CITY OF ALBUQUERQUE

September 29, 2021

Re: Singing Arrow Community Center
13200 Wenonah Ave SE
30-Day Temporary Certificate of Occupancy
Transportation Development Final Inspection
Engineer's/Architect's Stamp dated 4-23-21(AA) (L22D055)
Certification dated 9-27-21

## TITLE: ENLARGED SITE PLAN

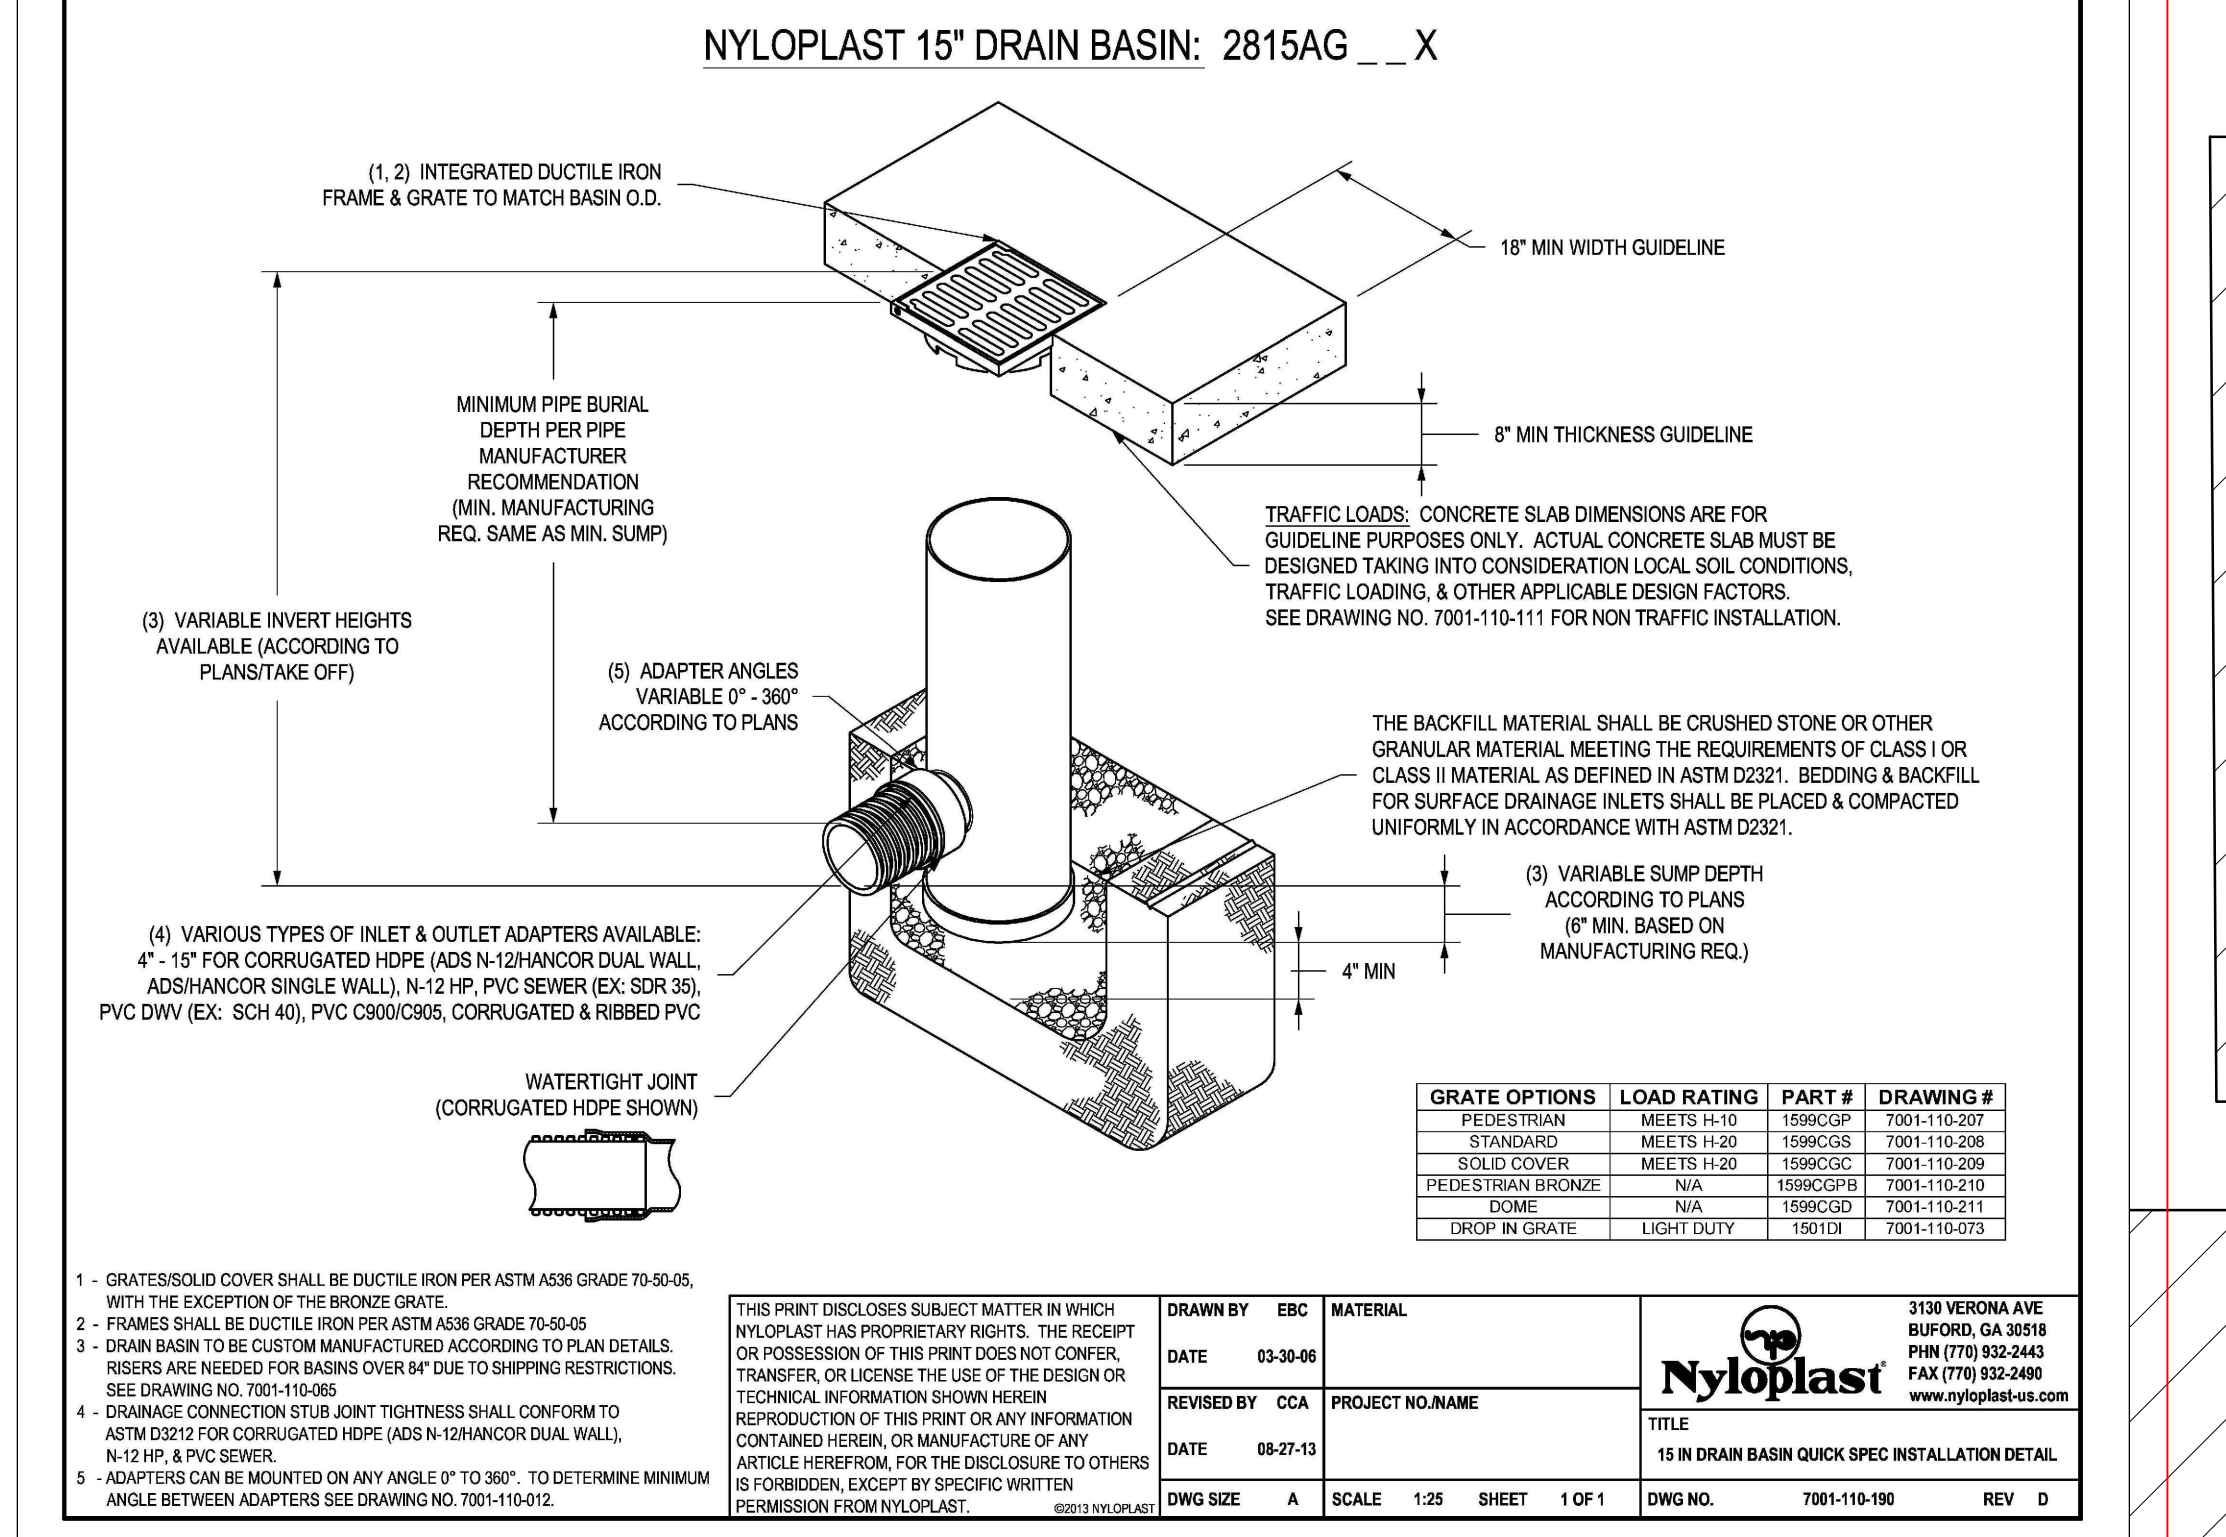
- Please add ADA signs. The ADA accessible parking sign must have the required language per 66-7-352.4C NMSA 1978 **"Violators Are Subject to a Fine and/or Towing."** If that language is present it is not visible in the detail.
- Remove security fence, landscape material in parking lot and construction equipment from site.
